SCOPING OPINION:

Proposed Kilnside Energy Park

Case Reference: EN0110022

31 July 2025

Drawing Title
Figure 14.1 Baseline Transport Network

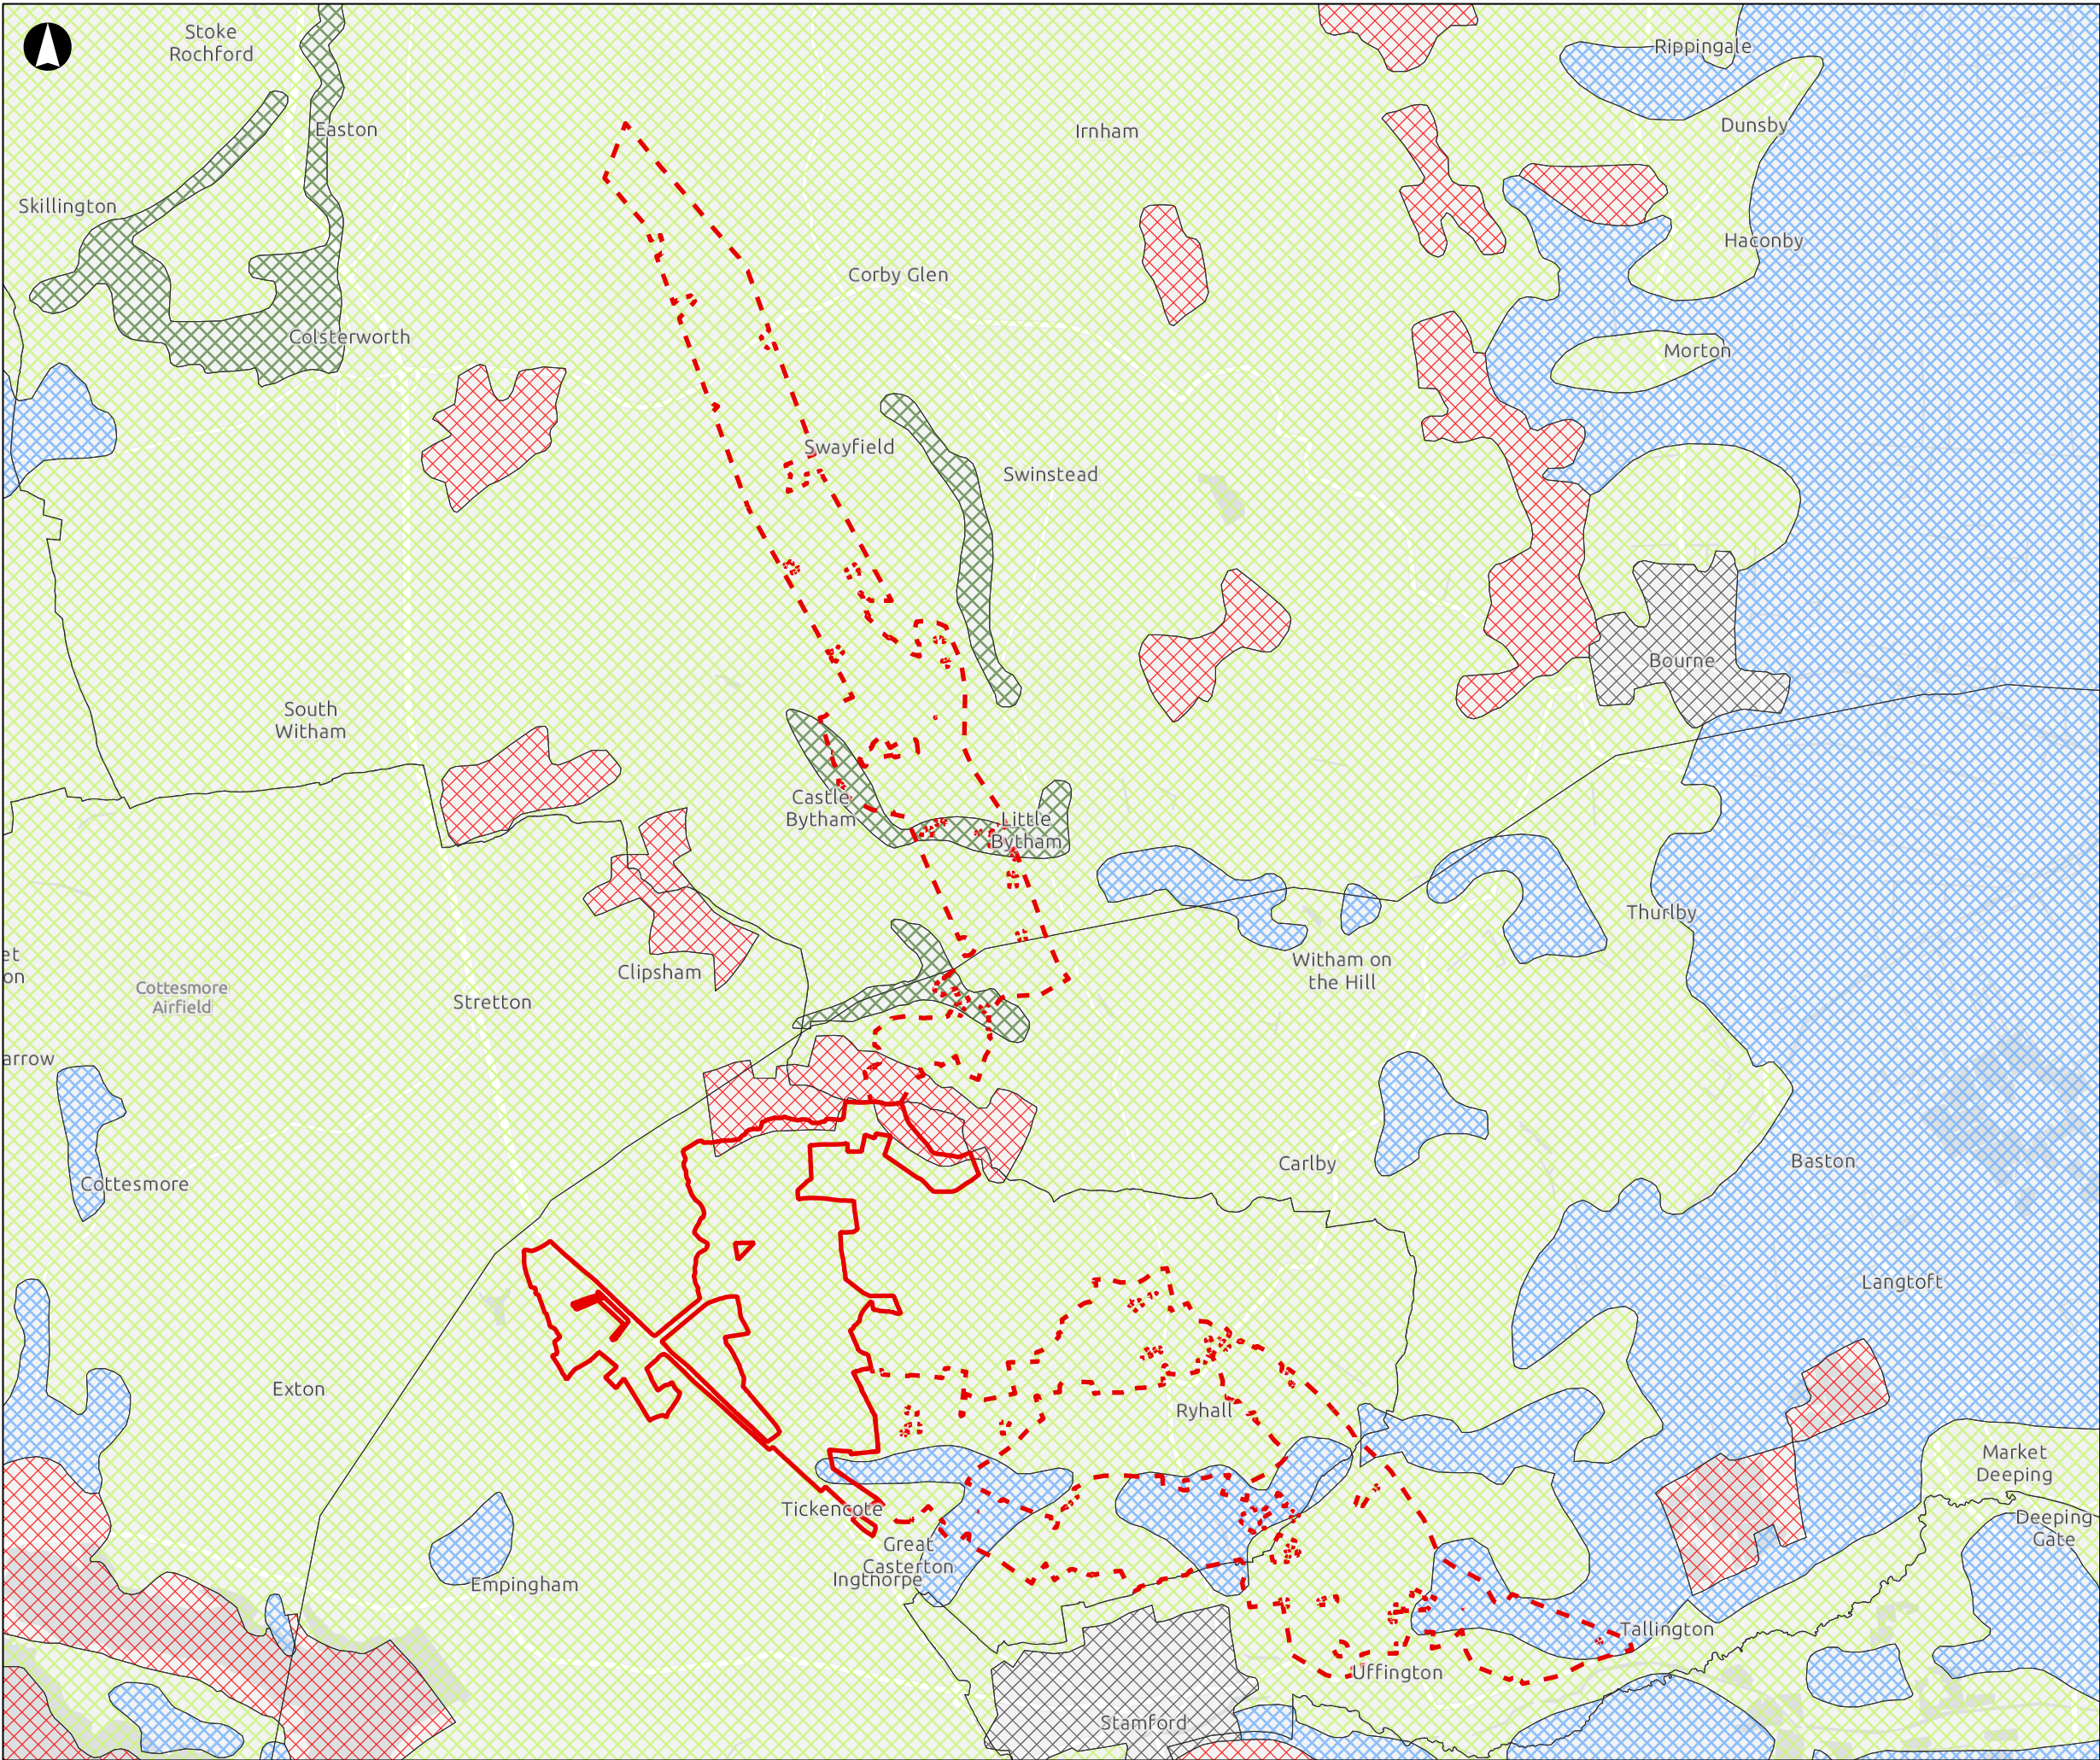
396	Para 14.2.1.3 and figure 14.1	Baseline PRow	The Scoping Report shows that the baseline transport network includes PRowS, but the information provided does not clearly identify extent of PRowS which could be affected. The ES should appropriately characterise the baseline for PRow and describe any alterations to PRow during all phases of the proposed development.
397	N/A	Traffic surveys	It is unclear whether traffic/ PRow surveys are to be proposed to inform the baseline. The Inspectorate notes that the study area has yet to be determined and the extent of affected transport networks is unknown. The ES should provide a robust baseline, including the use of traffic surveys if appropriate. Efforts should be made to agree the methodology with relevant highway authorities.
